**Parish:** Hatfield **Ward:** Hatfield Villages **Application Reference:**S6/2015/1469/FULL

**Description:** Erection of single storey rear extension and change of use from HMO to two apartments

**Location:** 4 Chipmunk Chase, Hatfield, AL10 9GH

**PROPOSED GROUND FLOOR PLAN**  
SCALE 1:50

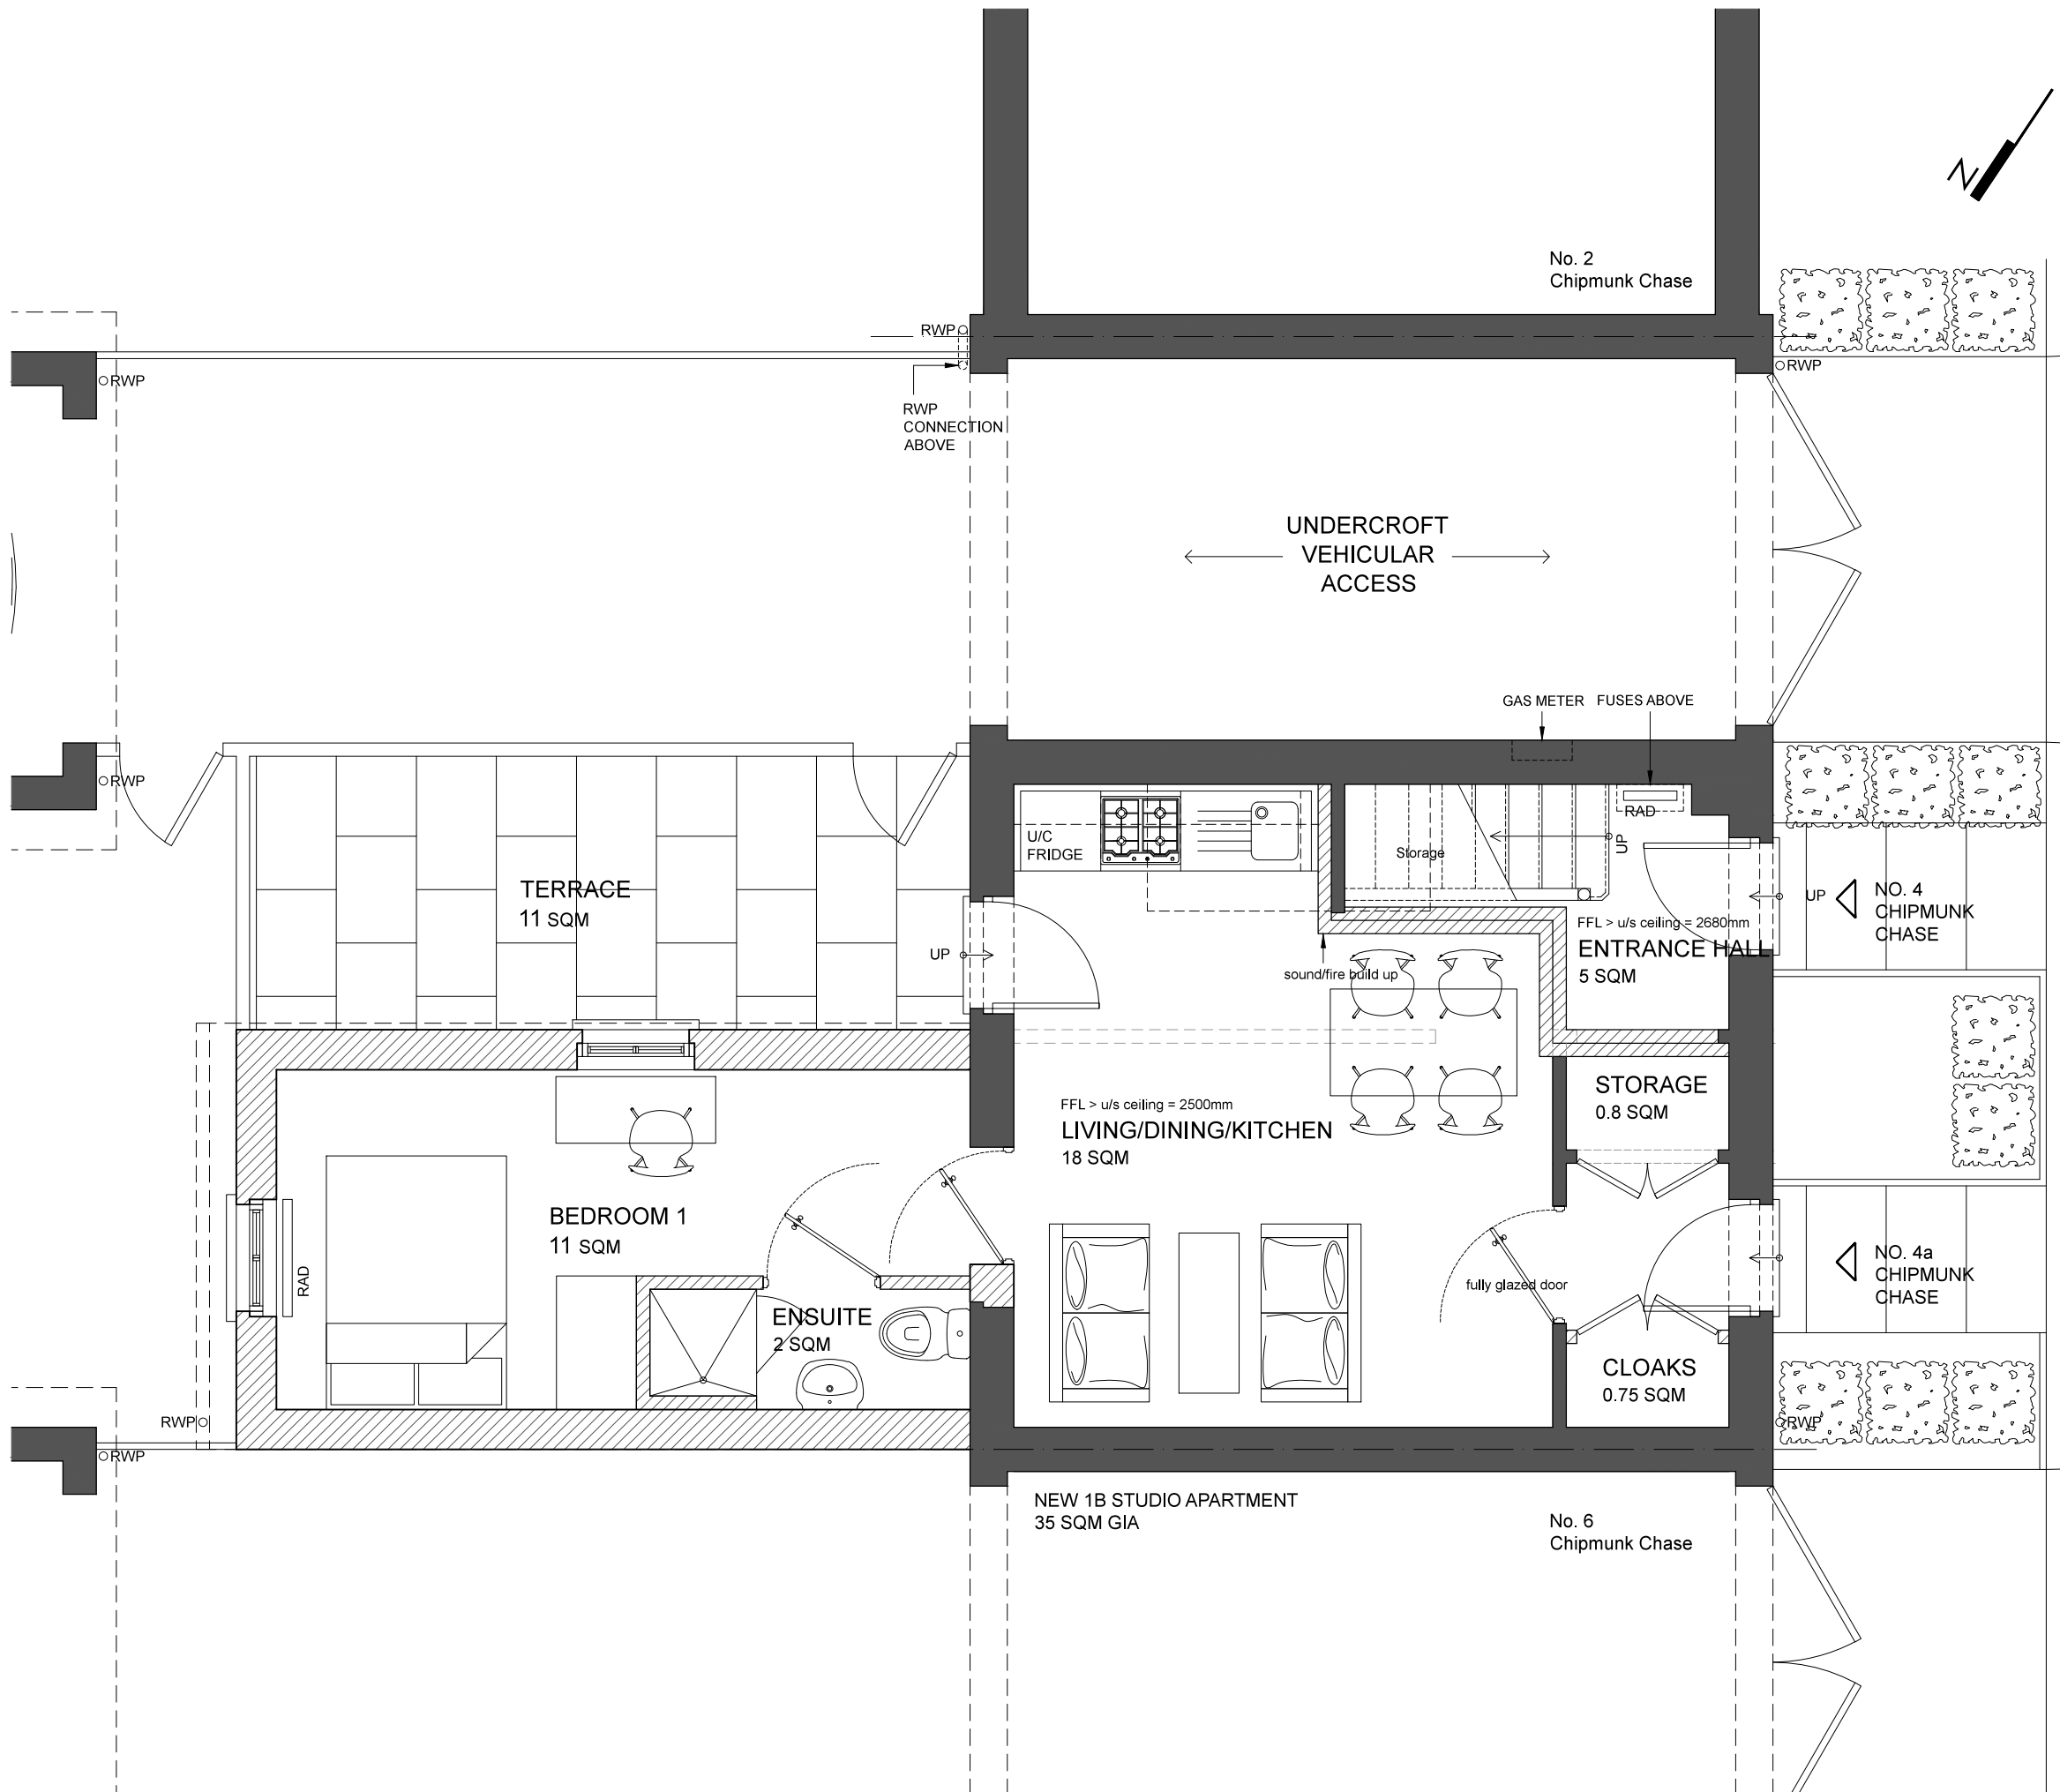
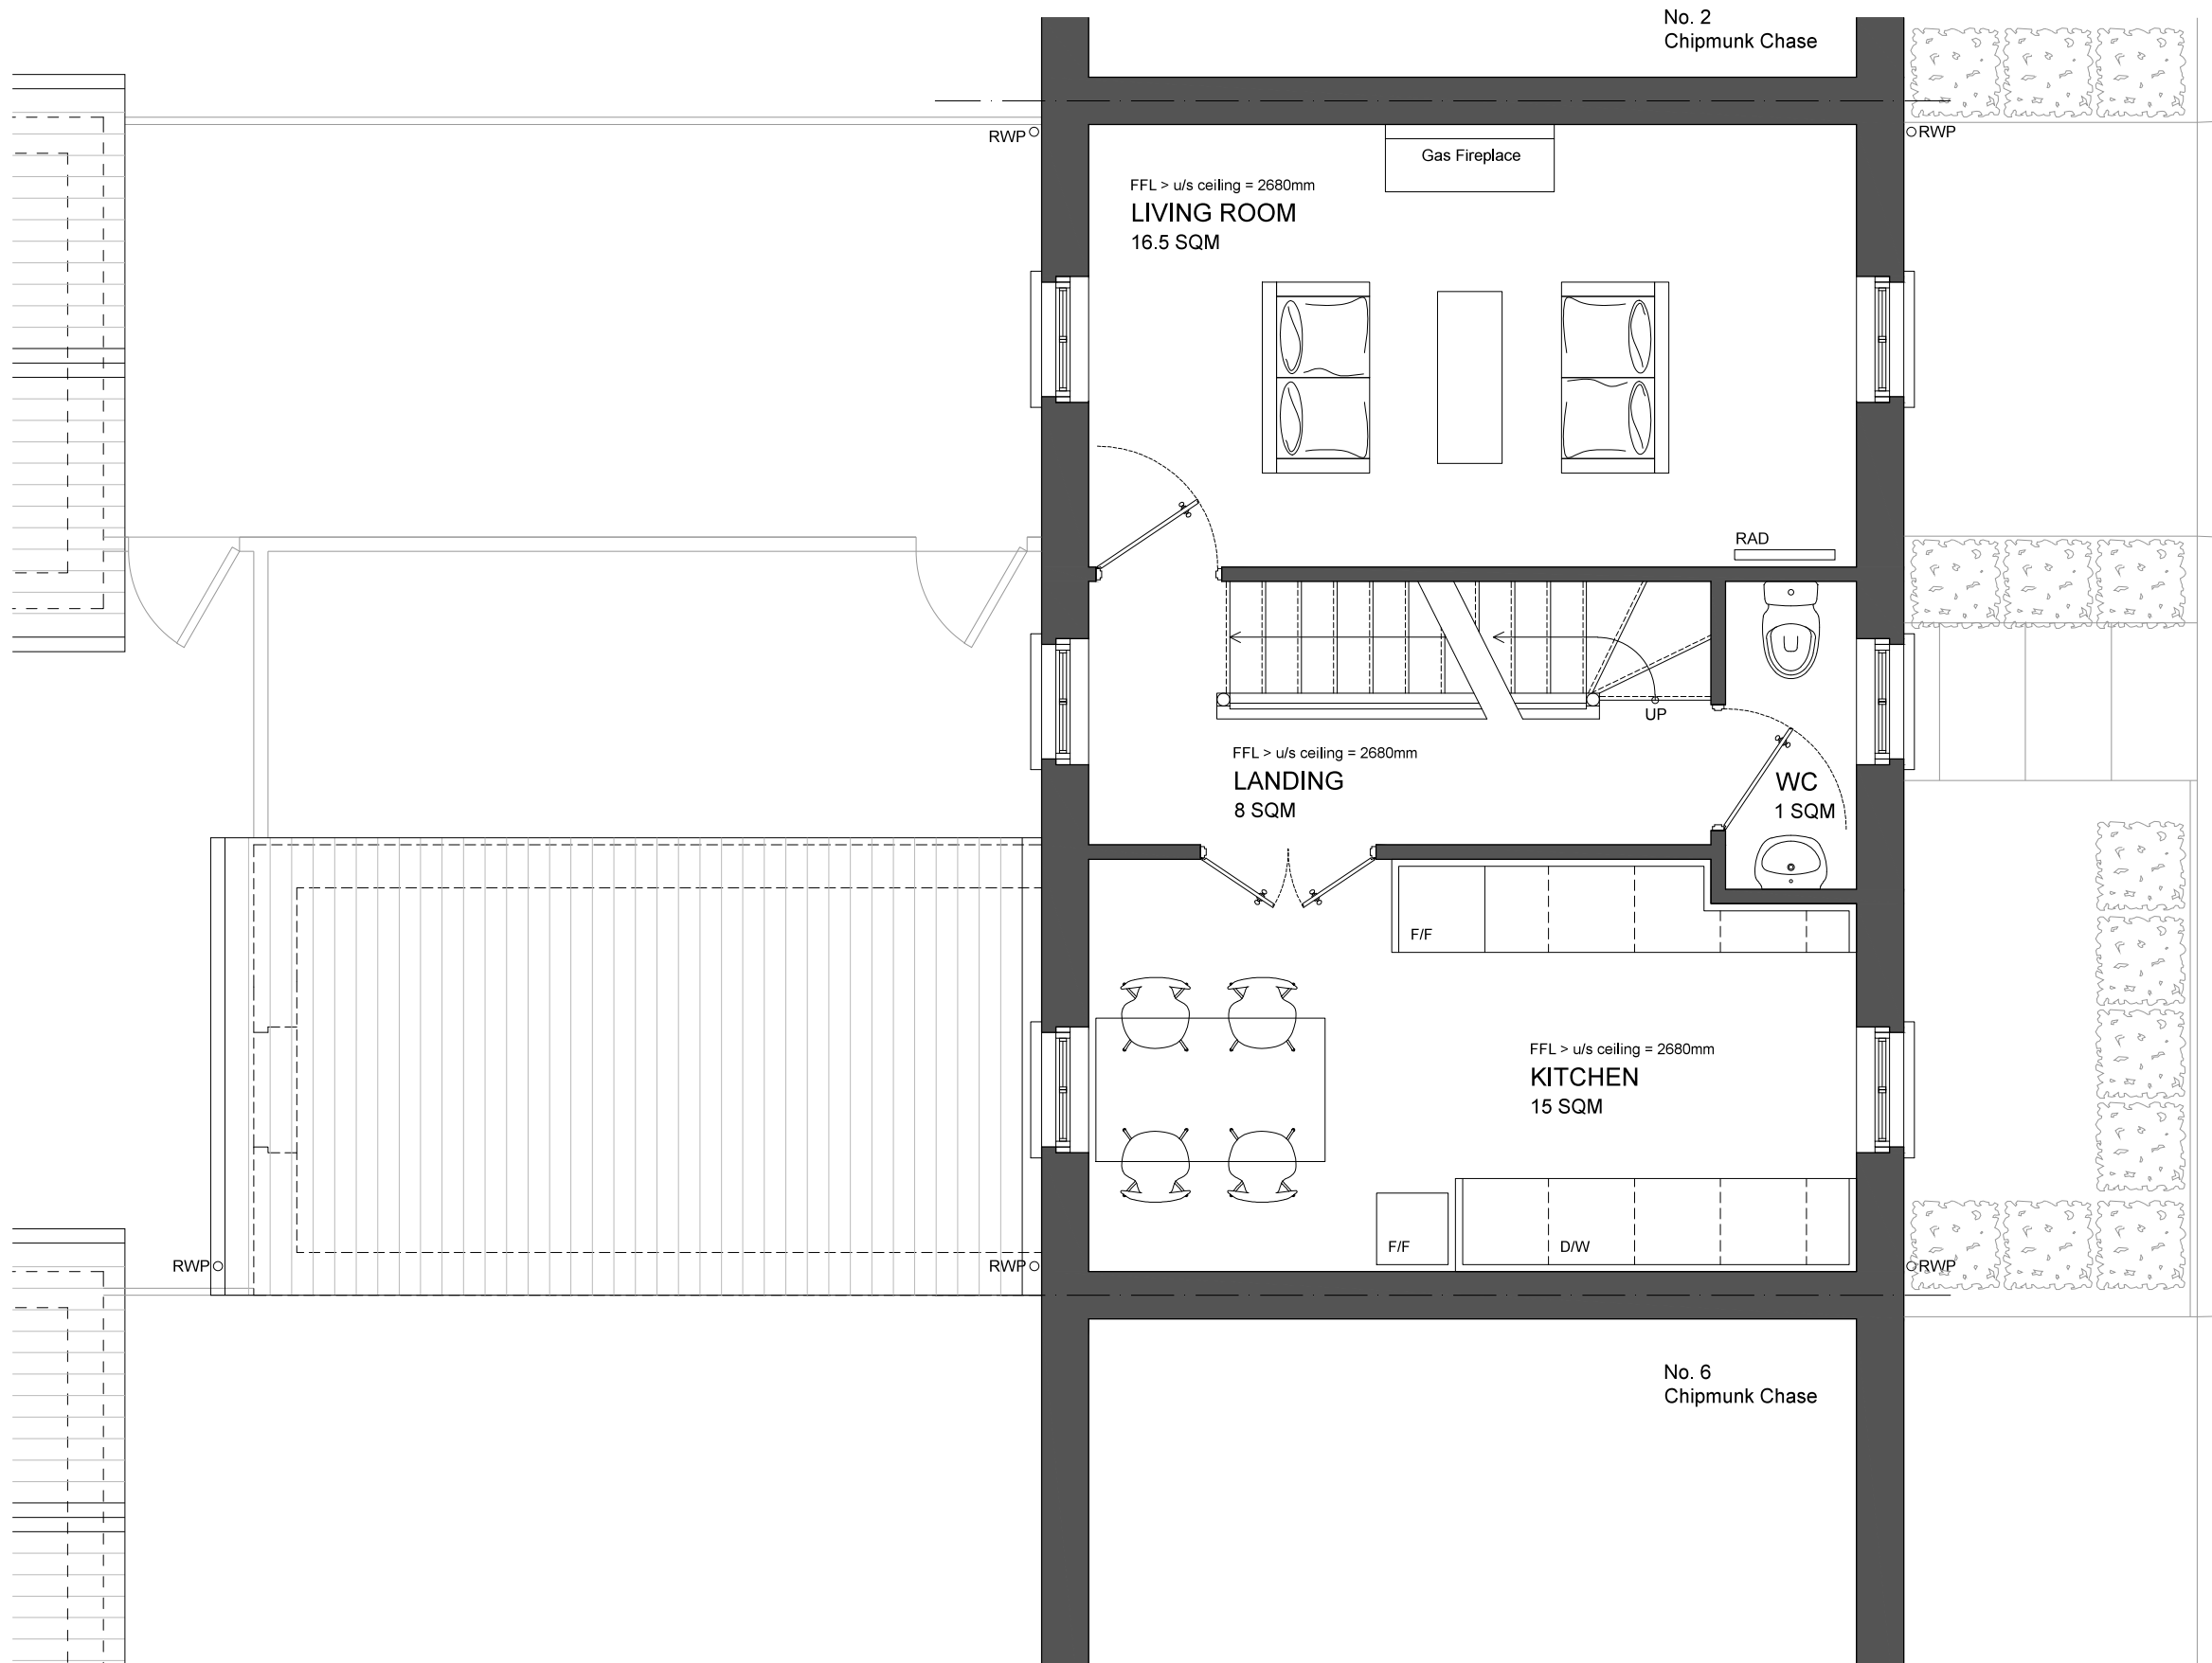
The Town Council questions whether this property is a licensed HMO and whether this application is a means of circumnavigating the licensing of HMO premises. The plans clearly indicate toilets within areas designated as bedrooms, therefore it has been concluded that the two apartments will still be let out to individuals to share communal spaces. The Town Council believes this application is overdevelopment of the site in an area already well developed and has insufficient acceptable parking in an area burdened with parking problems.

If the planning authority is minded to approve the application then the Town Council requests that the Article 4 direction for HMO's is applied from the outset so that the properties are let as two units to related individuals.
